Case Officer: Lewis Knox

Applicant: Eg Group

Proposal: Reserved matters application & condition discharge of Part B of 19/00128/HYBRID - Part B: Outline planning application - the development of up to 2 no. commercial buildings having a maximum floorspace of 16,890m² and having a flexible use [to enable changes in accordance with Part 6 Class V of the Town and Country Planning (General Permitted Development) Order 2015 (as amended)] within Class B2 or B8 of the Town and Country Planning (Use Classes) Order 1987 as amended, and ancillary Class B1 offices, with all other matters reserved for future approval (19/00128/HYBRID)

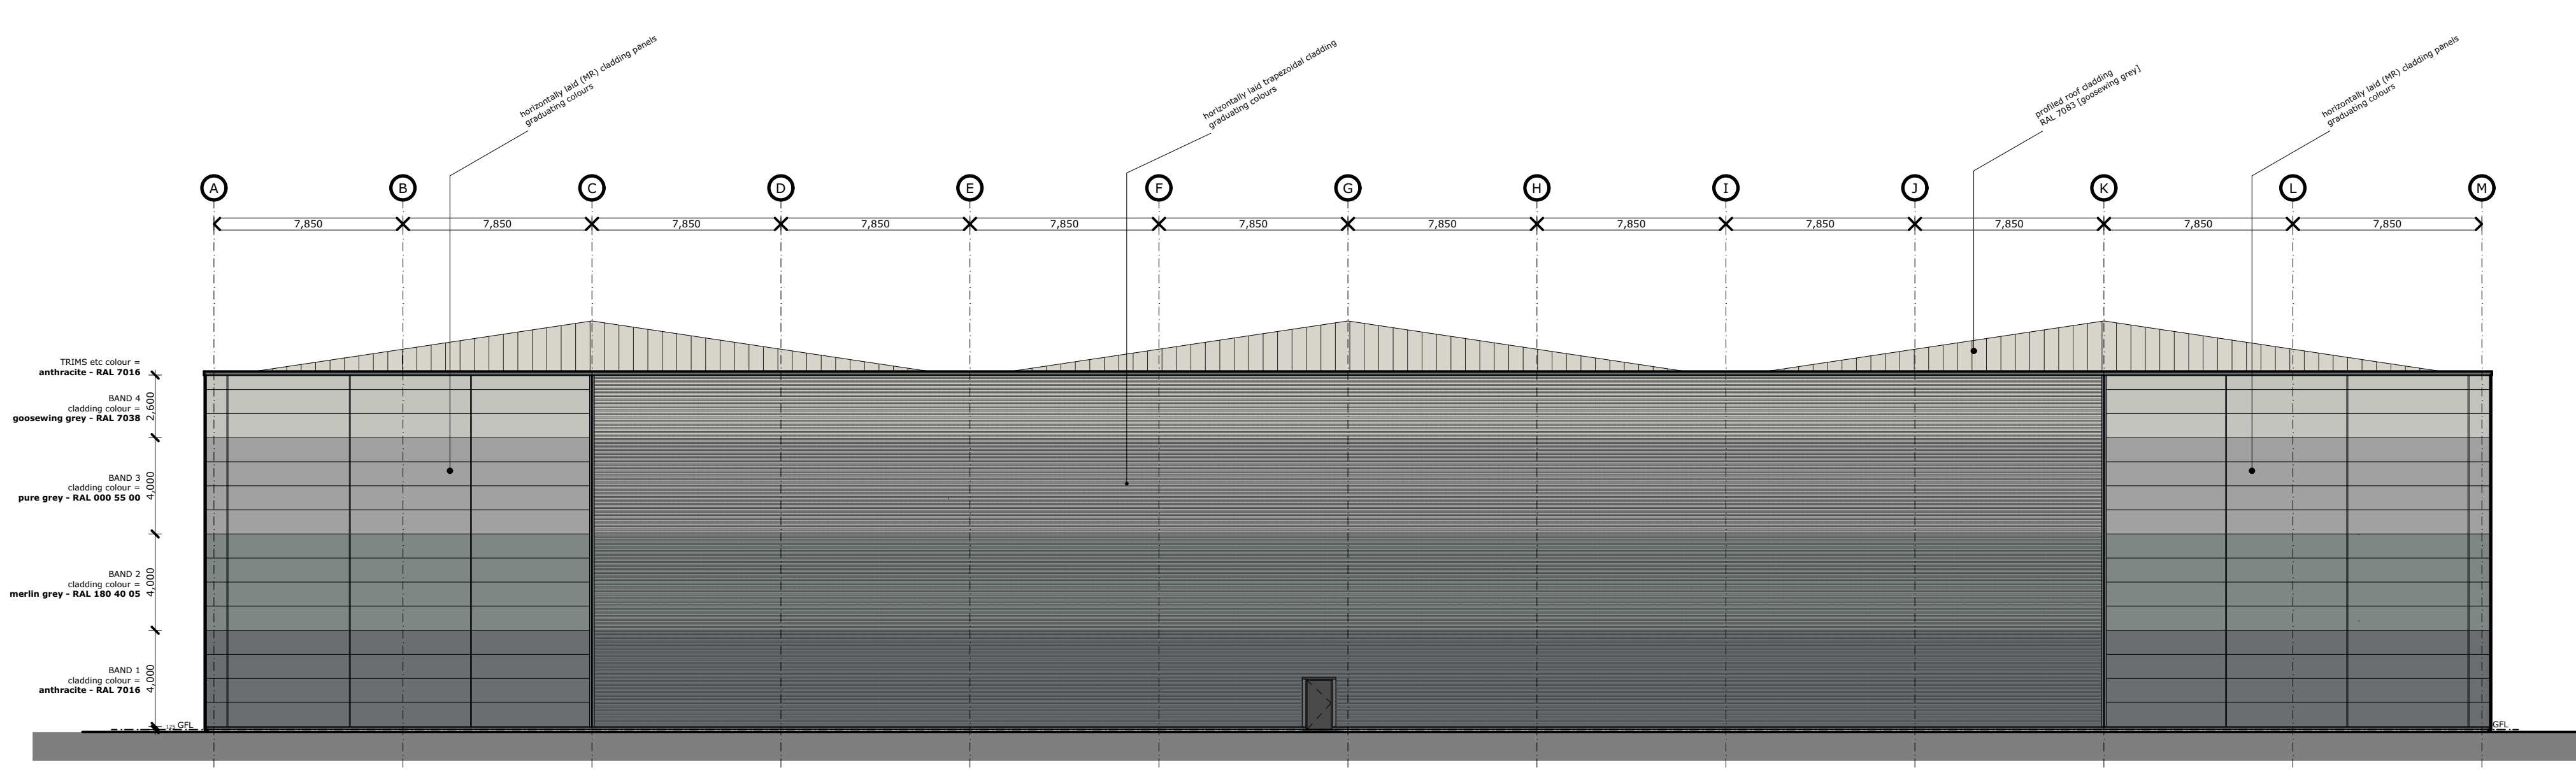
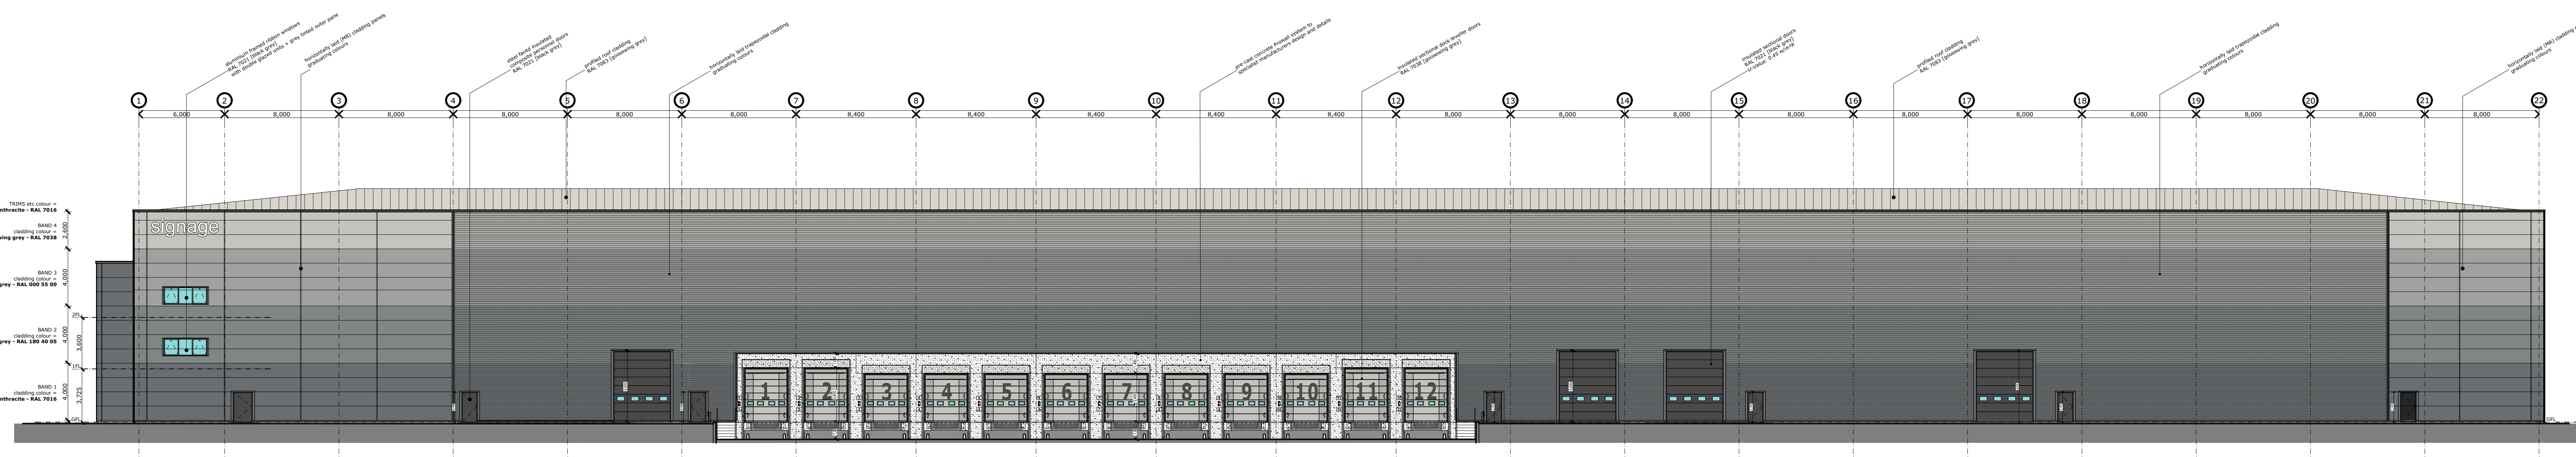
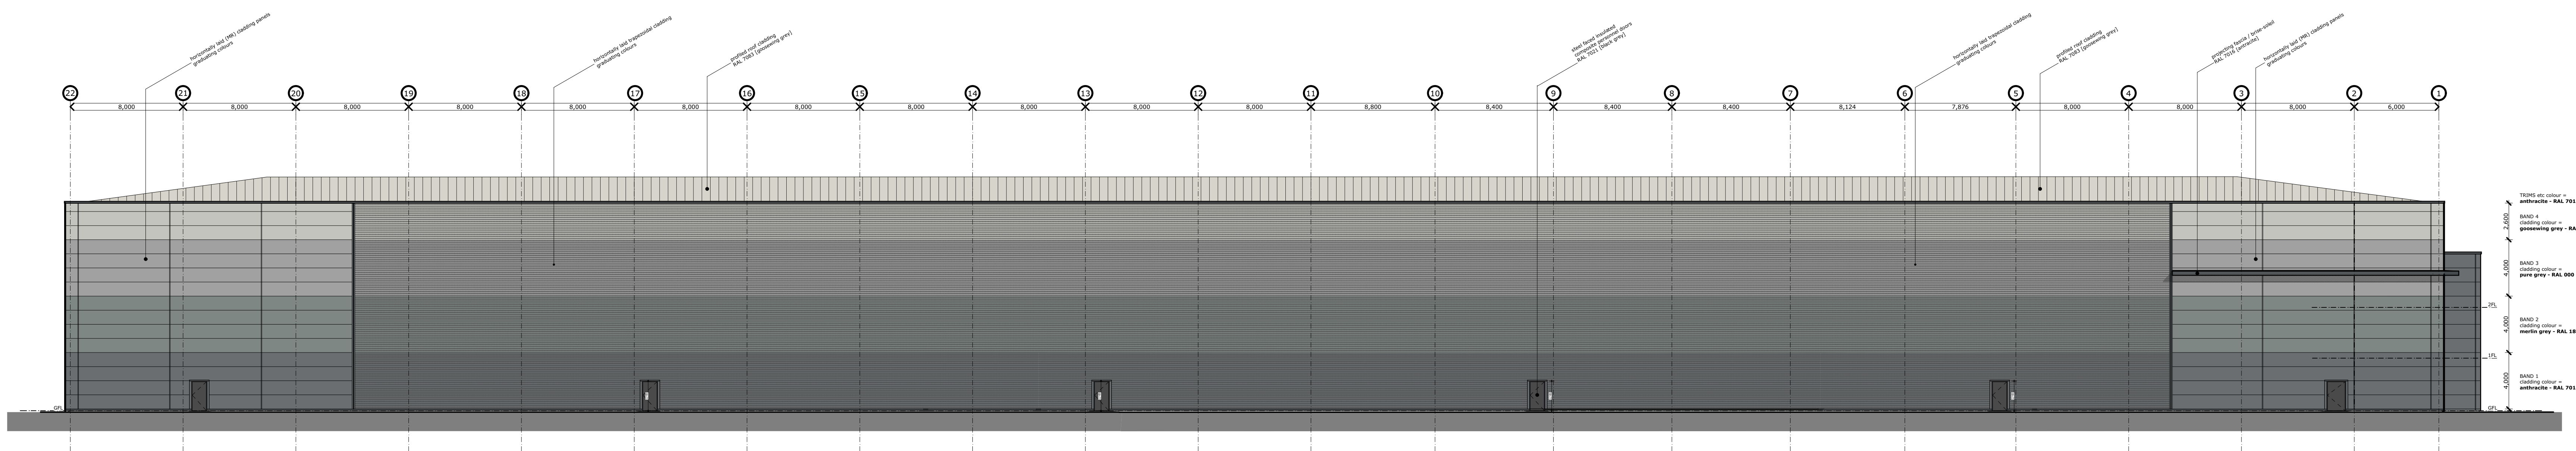
- 8.15. Given the more prominent positioning of the building with clear views of three of the elevations close to the M40 and Daventry Road, it is considered somewhat unfortunate that there is a slight lack of design variation to create visual interest to the south, east and west elevations. They would largely appear as large blank structures; although it is appreciated that this lack of visual interest is in large part due to the graduated cladding, which serves to reduce the perceived height of the building. On balance, the overall design is deemed appropriate in this instance.
